Re: Bus Connects Kimmage to City Centre core bus corridor scheme
Kimmage, Dublin

Bus Connects Dublin - Kimmage to City Centre Core Bus Corridor Scheme

Bord Pleanála Case reference: HA29N.317660

Programme Title BUSCONNECTS DUBLIN CORE BUS CORRIDORS INFRASTRUCTURE WORKS				
Drawing Title KIMMAGE TO CITY CENTRE CORE BUS CORRIDOR SCHEME GENERAL ARRANGEMENT				
Drawing File Name BCIDD-ROT-GEO_GA-0011_XX_00-DR-CR-0004	Sheet Number 04 of 14	Status A	Rev M01

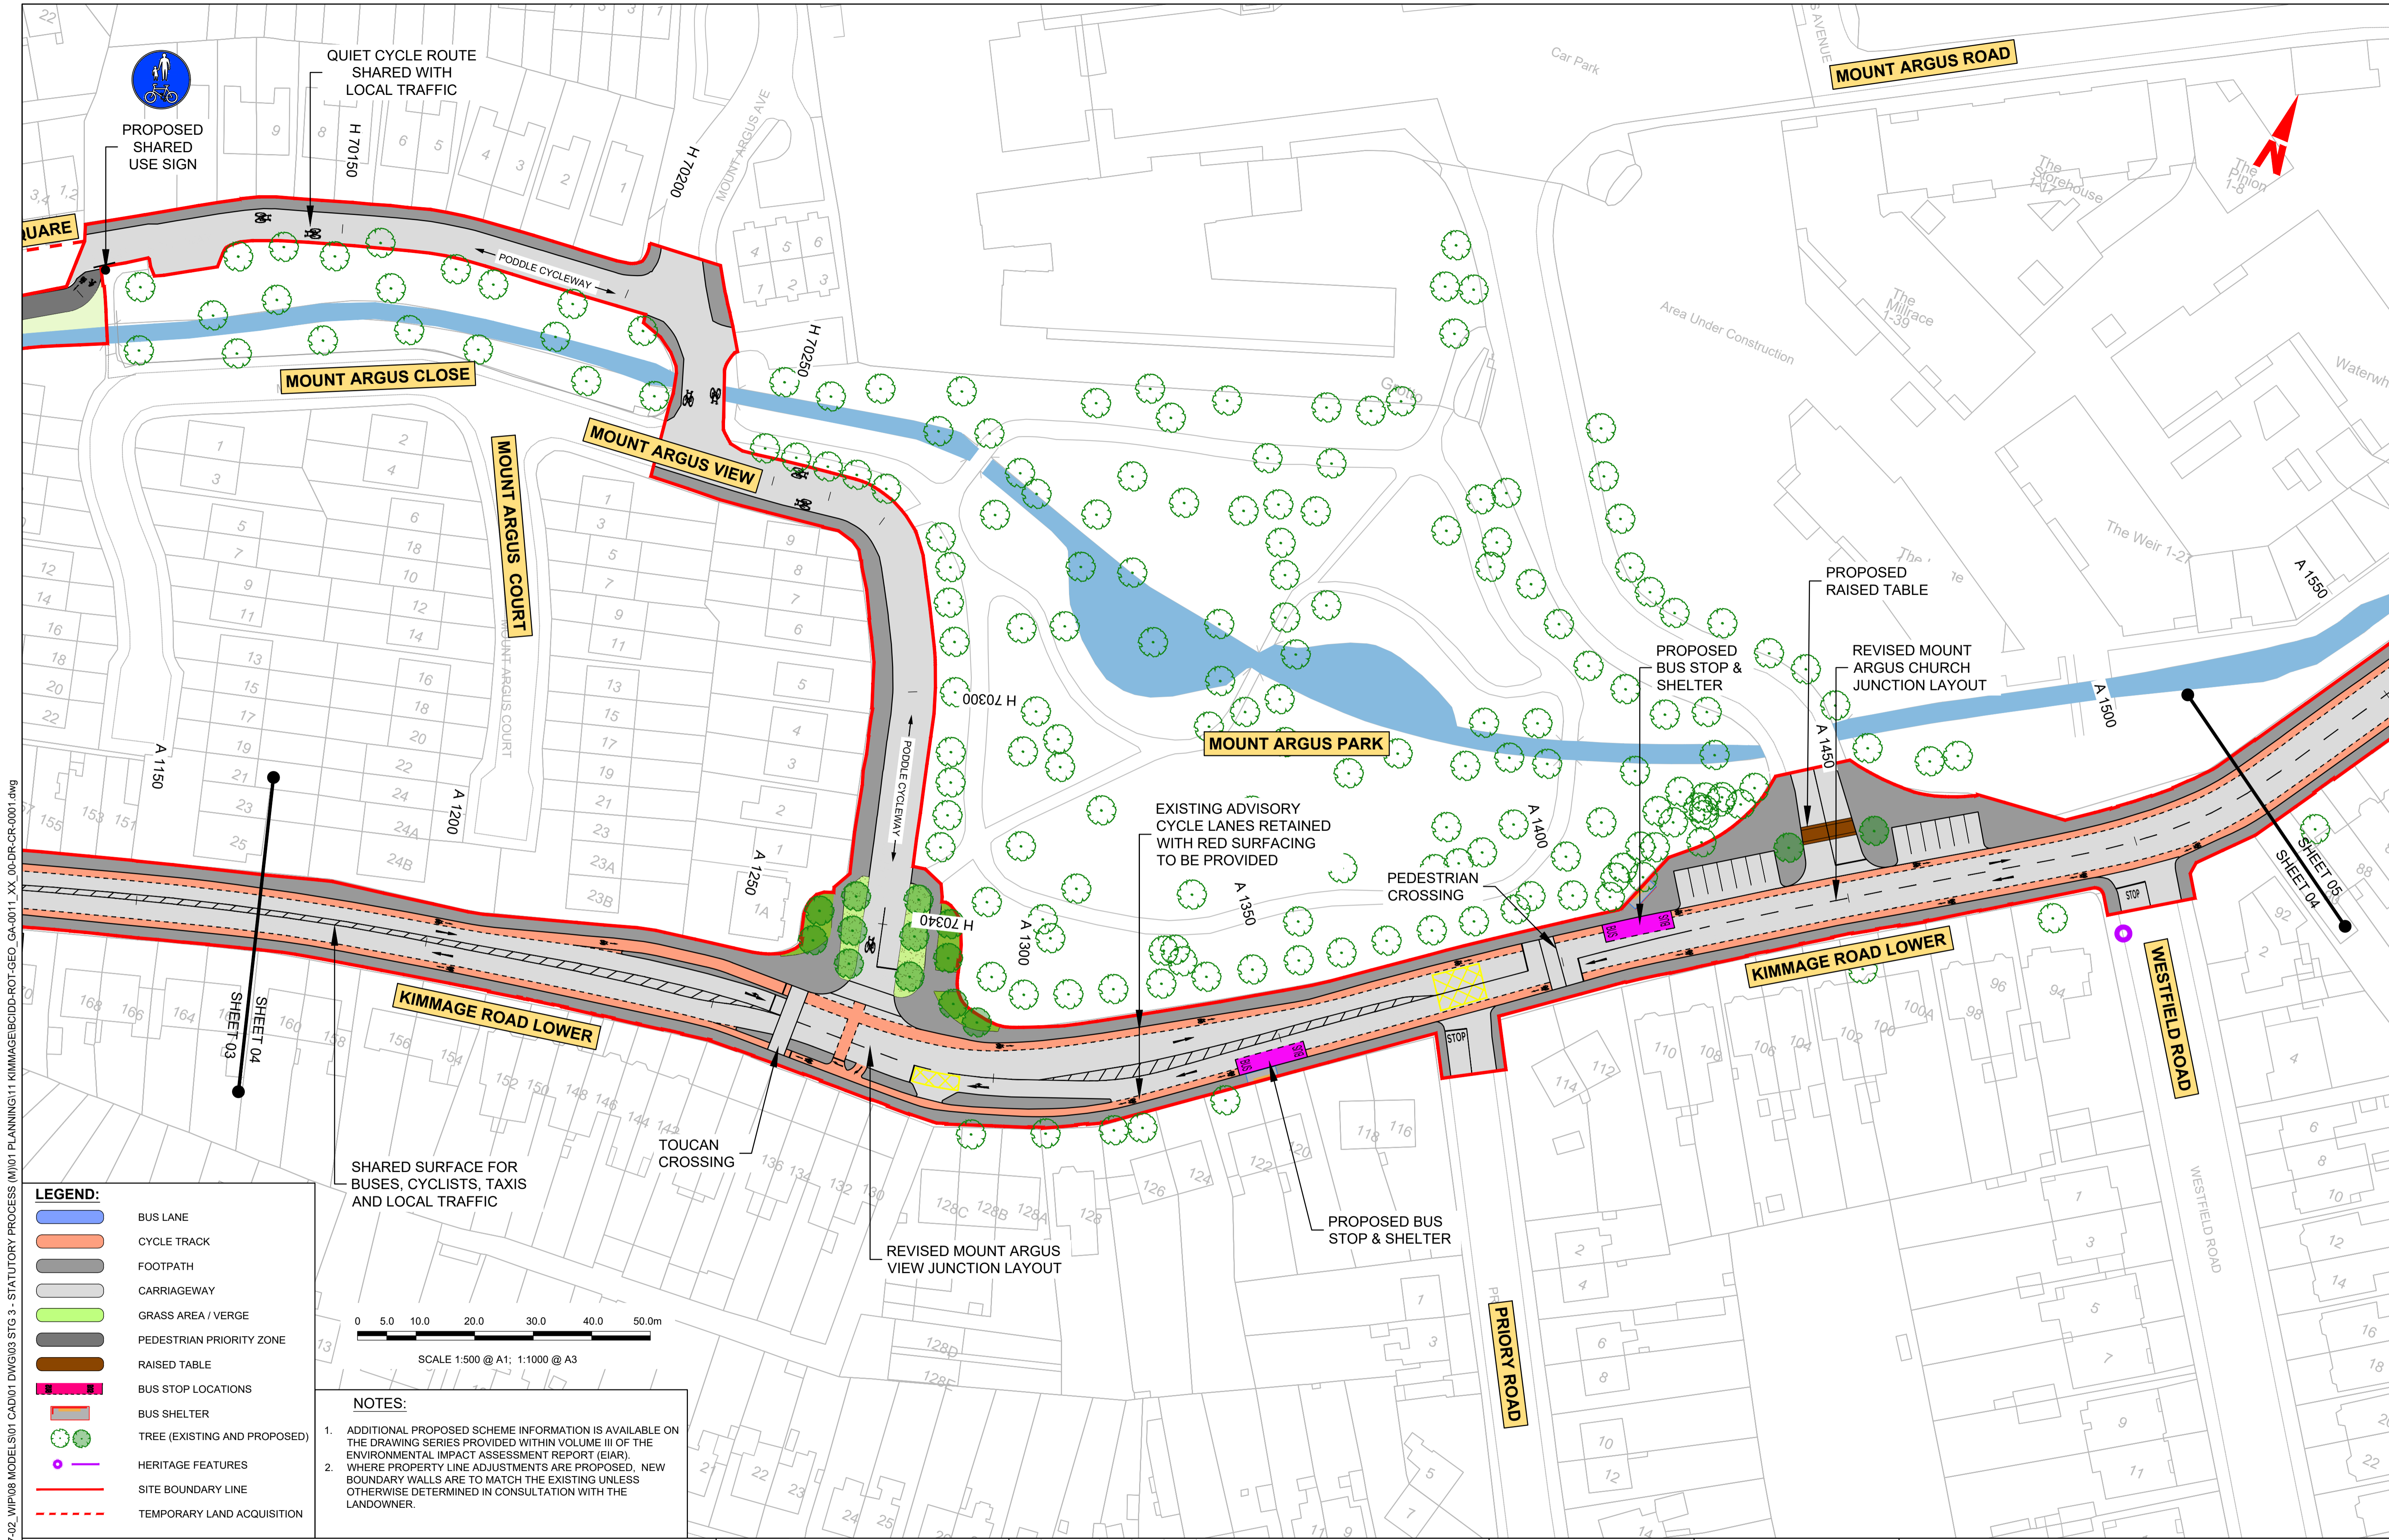
- The proposed construction of a bus stop shelter at bus stop 2391, Priory Road, is impractical due to the narrow width of the pavement at this location. Its introduction will lead to the

obstruction and limitation of my movement as I use a wheelchair, other pedestrians using mobility vehicles and children in prams and buggies, (see Appendix 3).

Bus Stop number 2391 - Shelter located at Priority Road – **OBJECTION:**

- The proposed introduction of this Bus shelter is impractical due to the narrow width of the pavement at this location. Its introduction will lead to obstruction of my movement as I use a wheelchair, other pedestrians using mobility vehicles and children in prams and buggies.

I request that the developers are instructed not to proceed with plans to build a bus shelter at this location

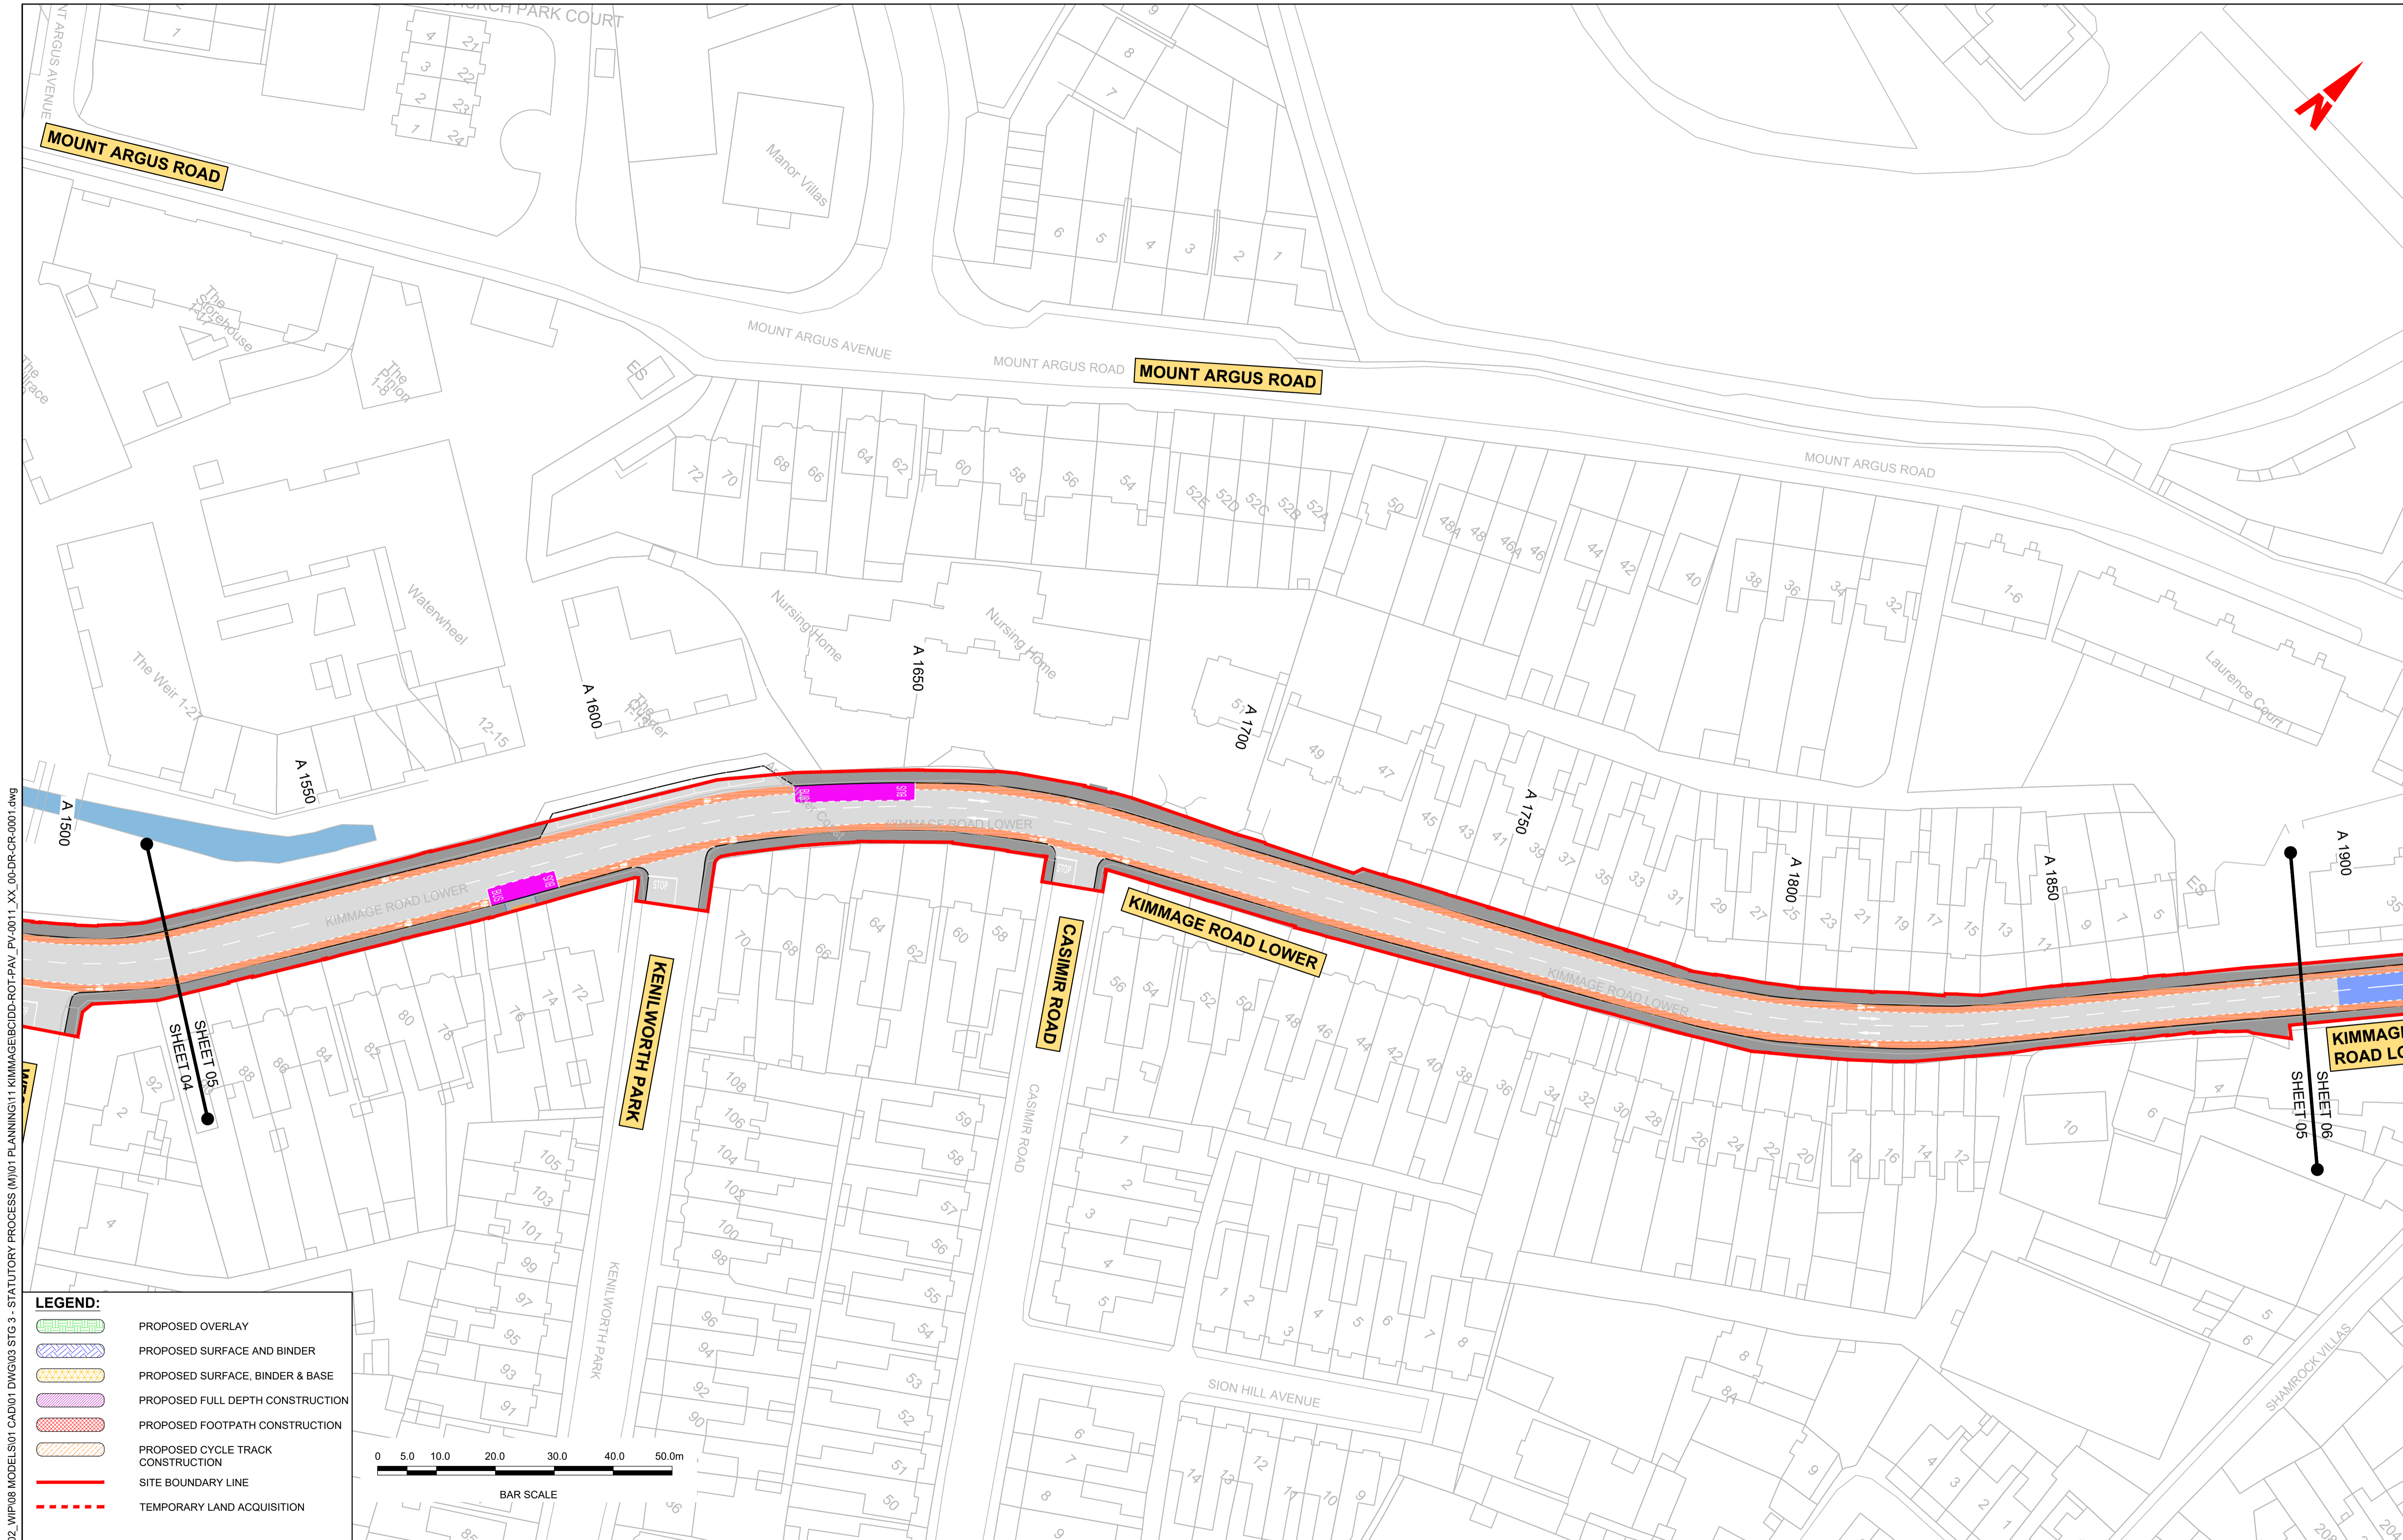
- The development plans propose additional raised paving on the section of Kimmage Road Lower from Numbers 126 to 136. Outside of major road junctions this is the **ONLY section of the entire Kimmage Road Lower where such additional raised paving is proposed. It is a wholly unnecessary and overbearing piece of development.** The gap between these proposed two (raised) pavements is too narrow to allow for unencumbered access and egress to and from a lane (located between numbers 128C and 130 Kimmage Road Lower) which is used for the ONLY vehicular access to the garage and my property, 128A Kimmage Road Lower, and for up to c.27* other properties, with that lane being also the only front and primary vehicular and home occupants access for my neighbours in the properties 128D and 128E Kimmage Road Lower. This obstruction means that vehicles will not have enough room to turn into and out of the lane and it will lead to those vehicles having to drive into oncoming traffic to effect that turning. (see Appendix 1)

- The imposition of the standalone raised pavements, from numbers 126 to 136 Kimmage Road Lower, segregating the cycle lane from the road, will obstruct and hinder ambulance services

- The imposition of the standalone raised pavements, from numbers 126 to 136 Kimmage Road Lower, segregating the cycle lane from the road, effectively prevents service vehicles, such as refuse collection, from directly accessing the related properties. It will create difficulties for Waste removal companies servicing properties numbered from 126 to 136 Kimmage Road Lower and will result in emptied bins being further strewn along the road. This practice (of not placing bins immediately outside of owning property) WILL be exacerbated, leading to pedestrian and possibly cyclists' movement obstruction.

The introduction of raised pavements along this section of Lower Kimmage Road appears to be random and sporadic and there is no discernible reason as to why they are placed at these specific positions. Their presence does however lead to problems and any notional benefits are outweighed by those problems.

- The gap between these proposed two (raised) pavements is too narrow to allow for unencumbered access and egress to and from a lane (located between numbers 128C and 130 Kimmage Road Lower) which is used for the ONLY vehicular access to the garage and my property, 128A Kimmage Road Lower, and for up to c.27* other properties, with that lane being also the only front and primary vehicular and home occupants access for properties 128D and 128E Kimmage Road Lower. This obstruction means that vehicles will not have enough room to turn into and out of the lane and it will lead to those vehicles having to drive into oncoming traffic to effect that turning. *Numbers 128-152 Kimmage Road Lower and numbers 14-23 Larkfield Avenue.

- The imposition of the standalone raised pavements, from numbers 126 to 136 Kimmage Road Lower, segregating the cycle lane from the road, will hinder ambulance services accessing me quickly in the event of emergency, and similar access to residents of related properties.

I request that the developers are instructed to modify their plans and remove the proposed section of unnecessary paving from the proposed development. The proposed section of paving is approximately 50m long and as stated above appears to be the ONLY such section outside of major junctions. It is a wholly unnecessary and overbearing piece of development.

Design amendment required: the proposed raised pavements in front of numbers 126 to 136 Kimmage Road Lower should be removed. Should any alternative structures be proposed, then they too MUST NOT give rise to the above identified problems.
